Comments for Planning Application 21/00167/HHD

Address: 4 Fox Close Bampton Oxfordshire OX18 2NH

Proposal: Demolition of existing conservatory, garage and single storey rear and side structure.
Erection of two storey side and single and two storey rear extensions.

Comment Details

Drawing Title:
Proposed Elevations

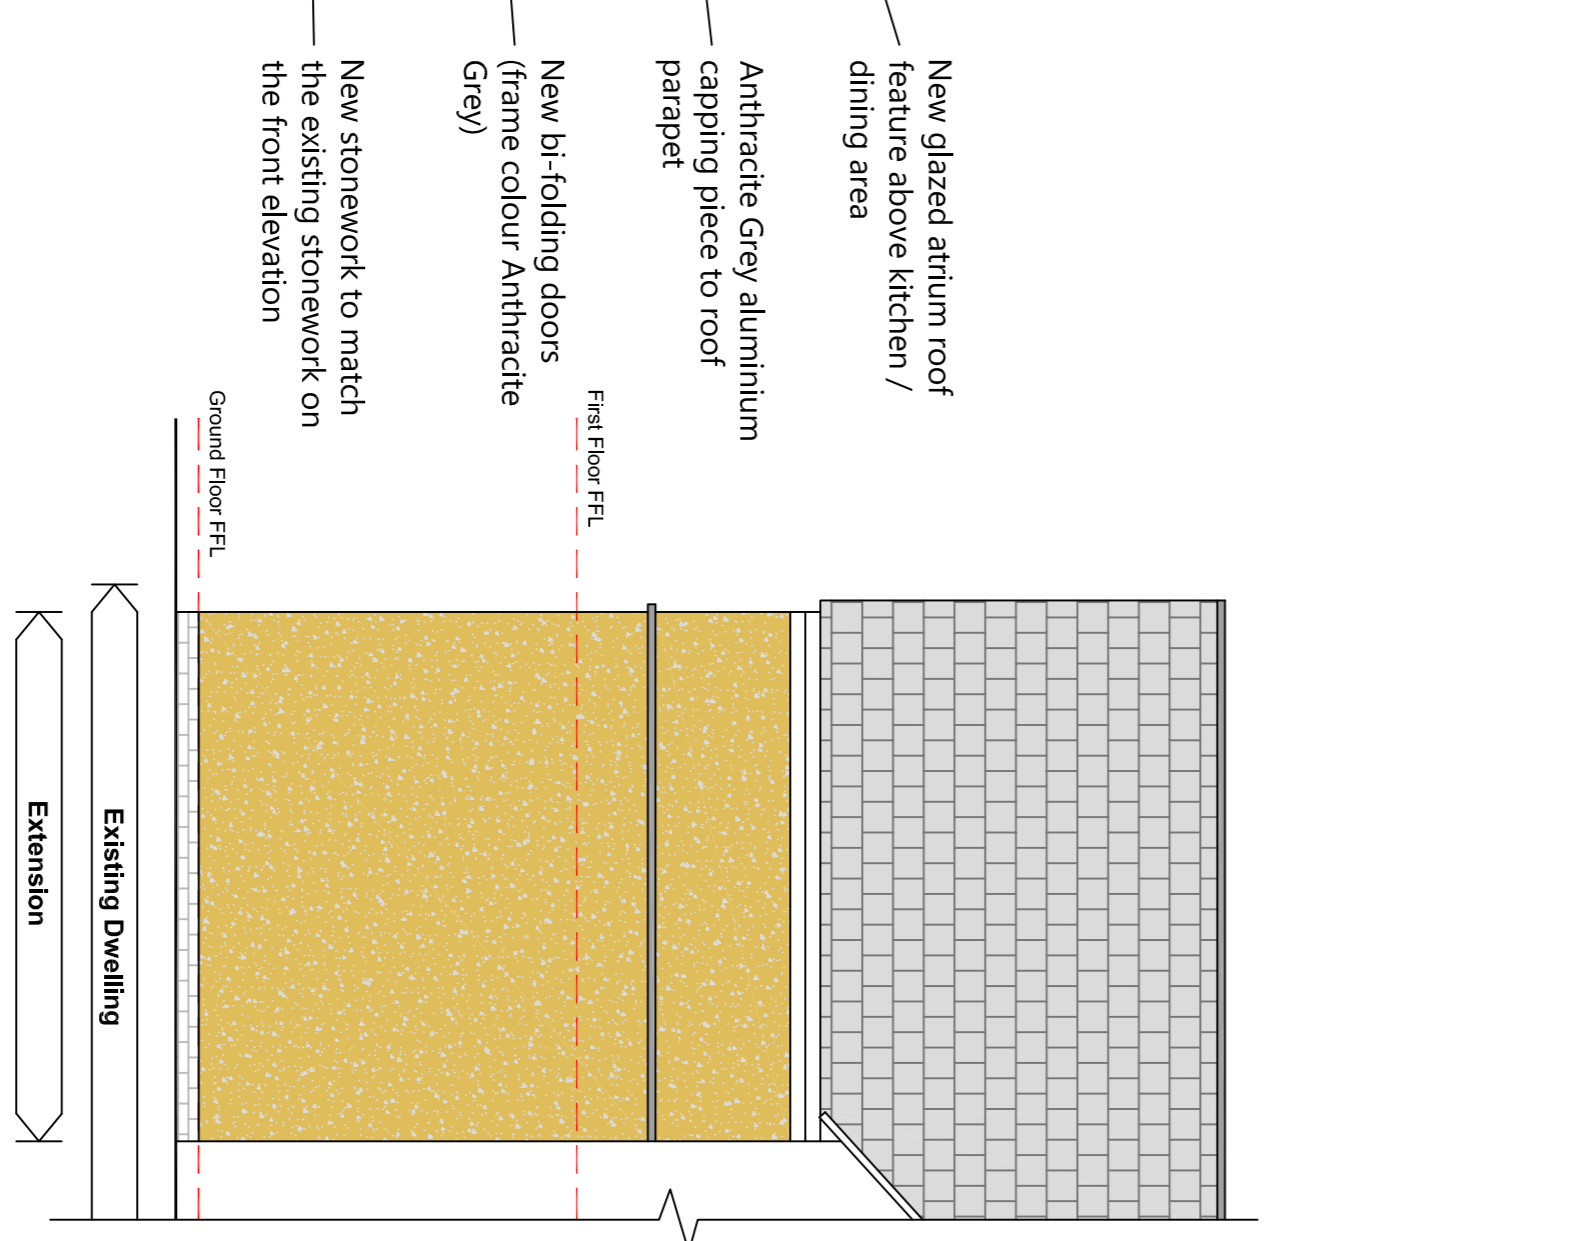
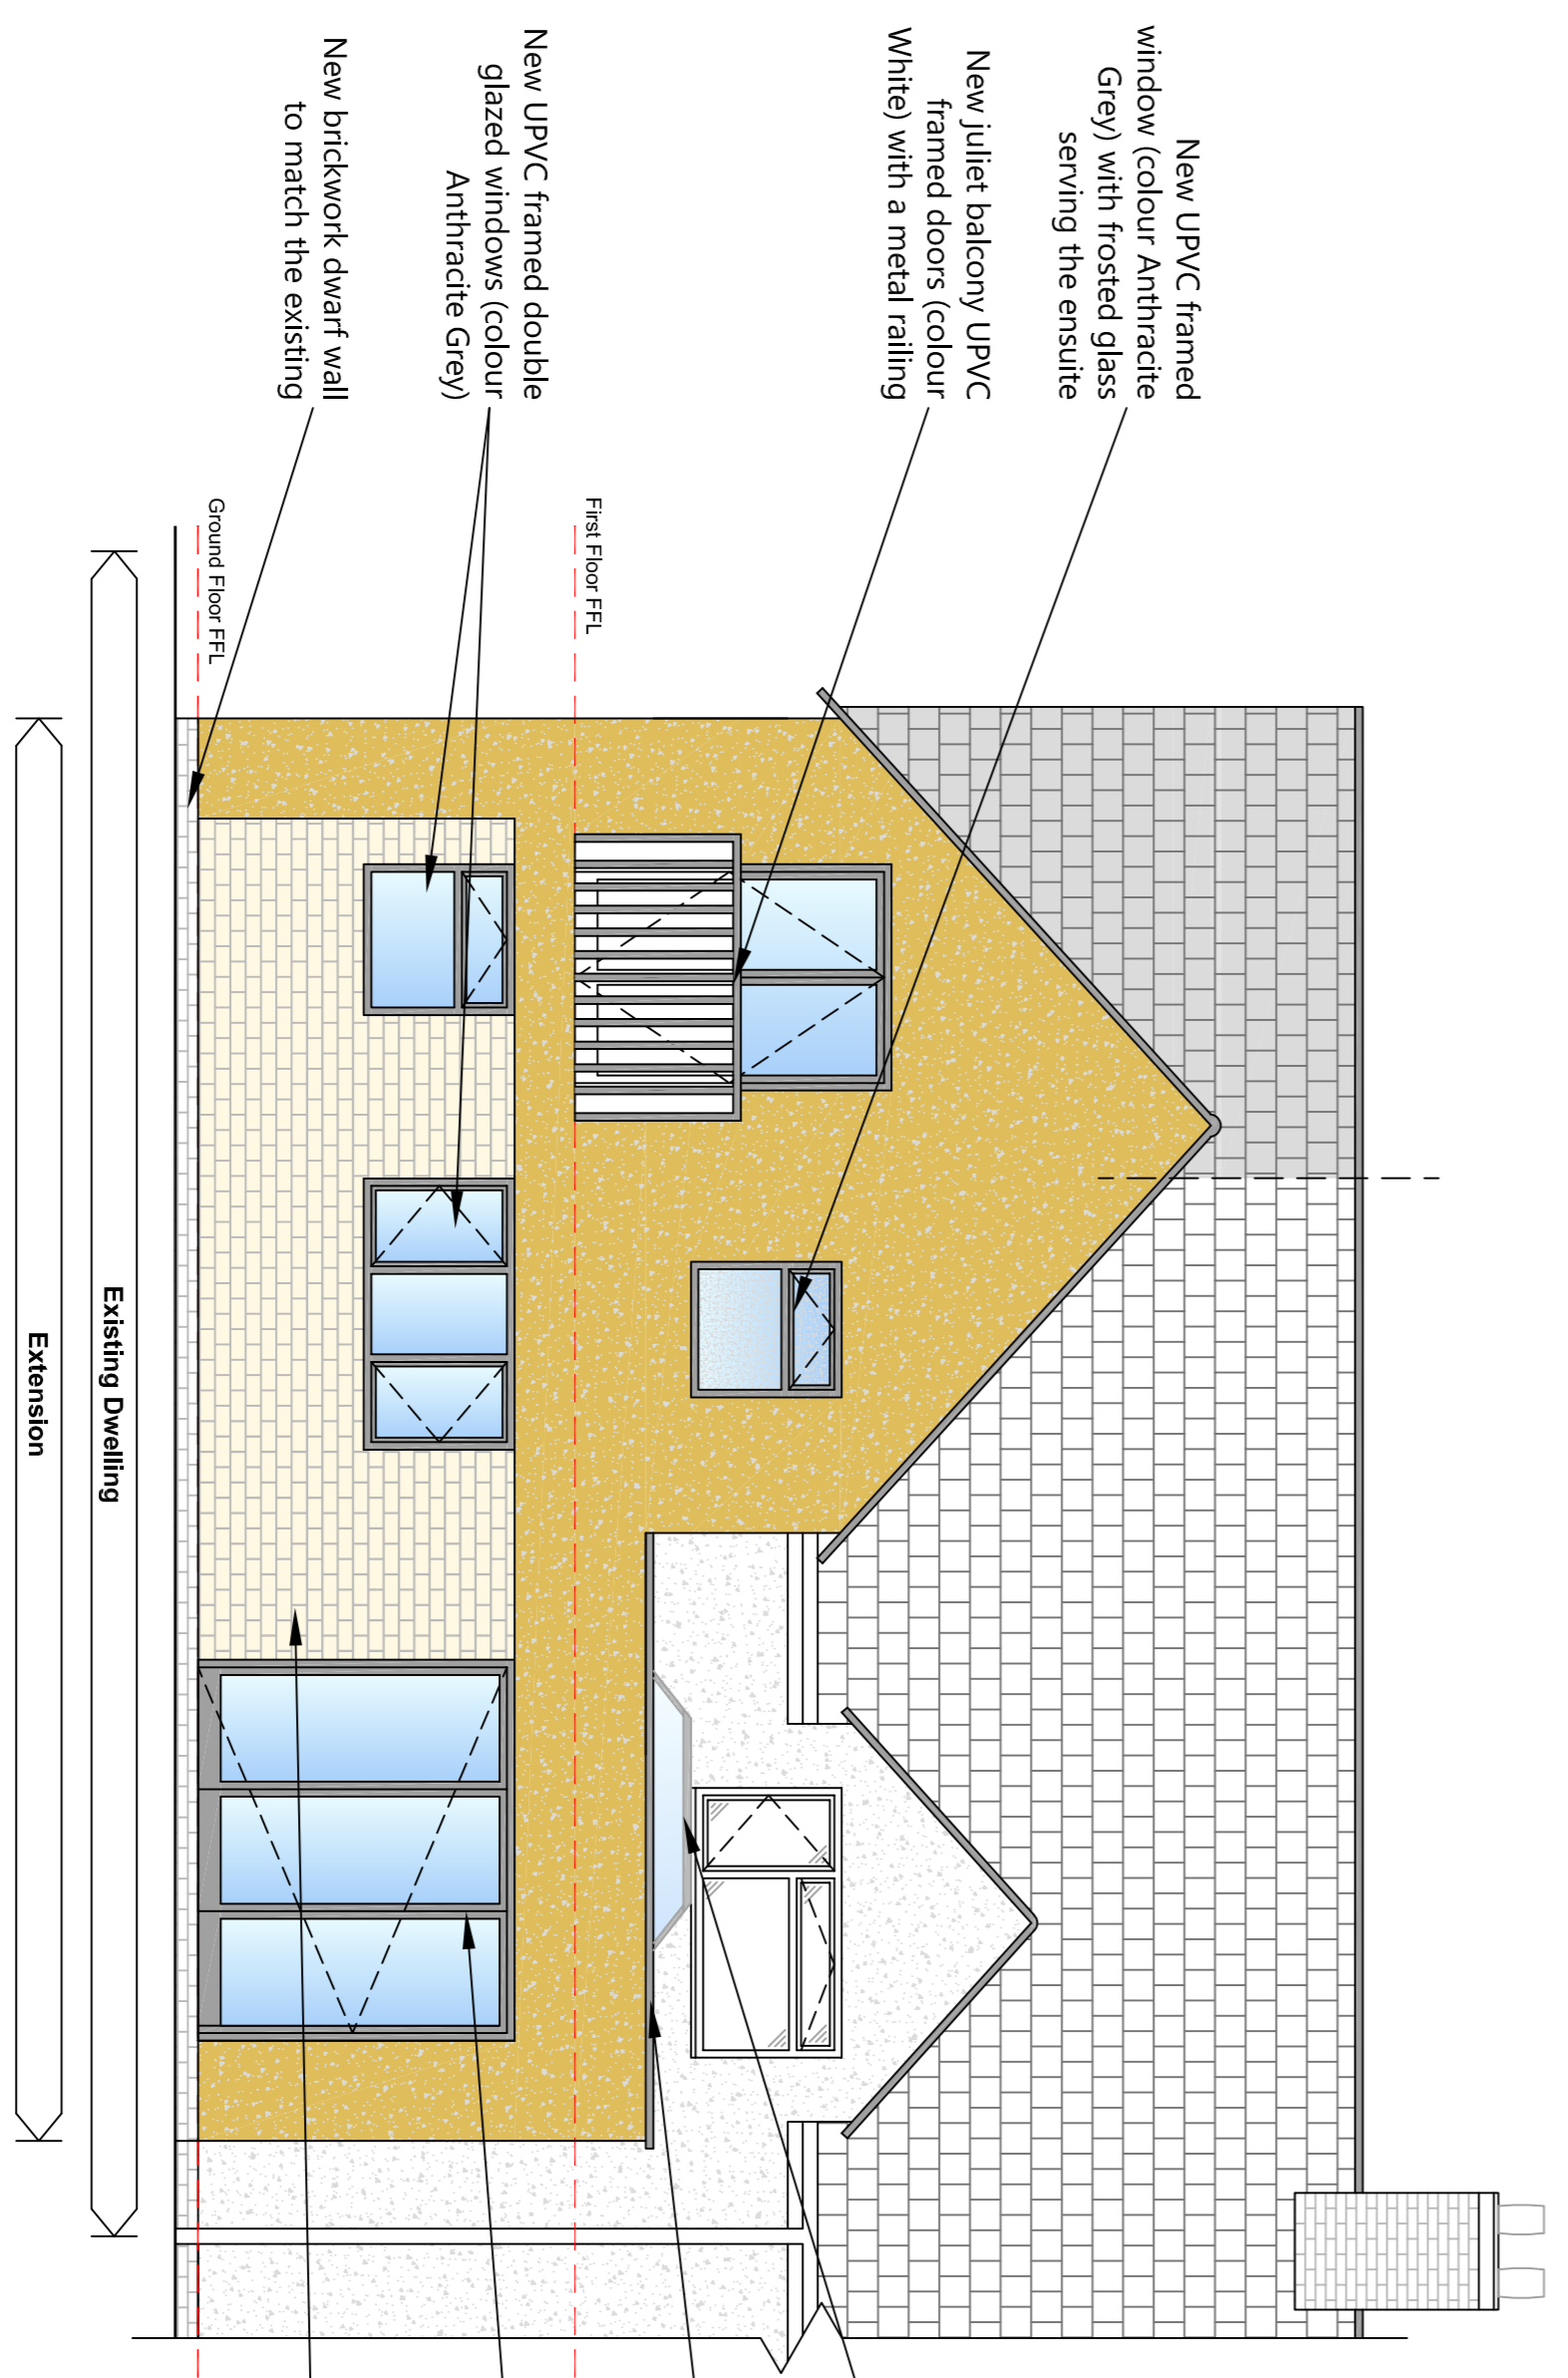
Loss of Privacy: from proposed second storey planned rear bedroom and balcony. The view from this new window and second floor extension will give a view into my sitting room. I note on the proposal that no window was planned to the side to avoid any potential overlooking the neighbouring property, however side bedroom windows already exist in both properties. This same consideration of 'overlooking' has not been given to my property which is to the rear.

As upper bedroom side windows already exist in no 4 and neighbouring house, would it not be more appropriate to keep windows to side of the property as there is already a precedent for this and less risk of 'overlooking' than relocating to the rear of the property?
